Application Ref: R/64/17/PL

10 July 2017

Re: Objection to St Mary's Close amended development proposal

Drg No: 151117_SS-01 Rev: D

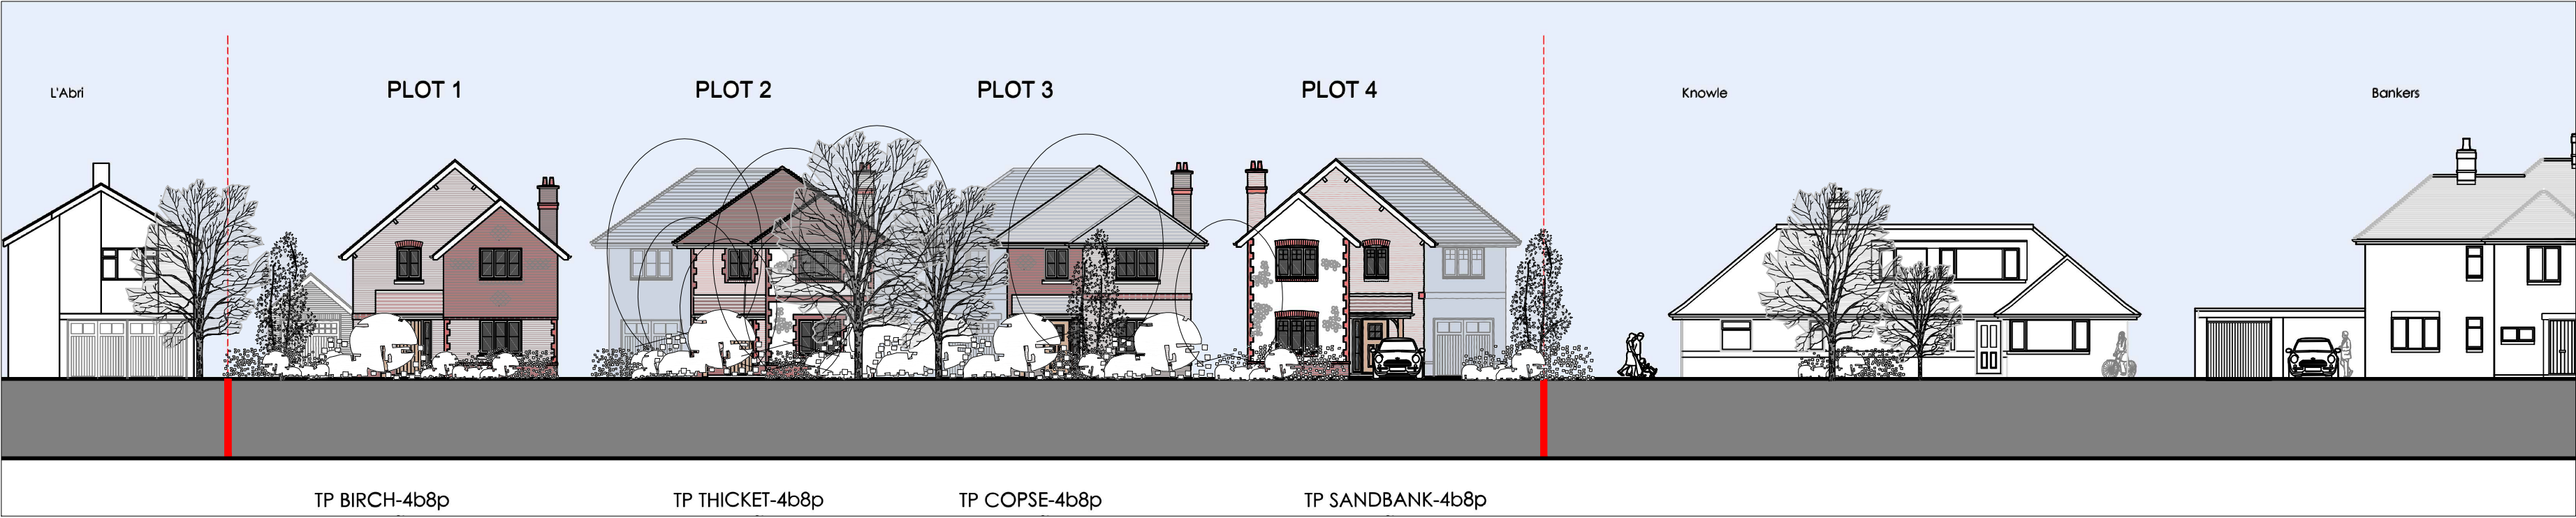
- Taking the measurements from the developer's street scene drawing (SS-01)⁽¹⁾ the distance between the eaves of the 4 houses was, on average, approximately 1.6 meters. It is not possible to measure these distances accurately on the new drawing (SS-02) but the average distance between eaves is now less than 1.6 meters. For the rest of the road the average distance between eaves is roughly 4.8 meters. This means the houses in the proposed development will be 3.2 meters closer together than the average for the rest of the road. From a distance, or a side long view, the new houses will look like they are almost touching each other and will be indistinguishable from a row of terraced houses.

(1) The developer's drawing SS-01 is inconsistent with other drawings he has submitted in terms of measurement. It seems this, and the use of light shading on the left hand side of houses, is an attempt to exaggerate the distances between the 4 houses and make his proposal more appealing.
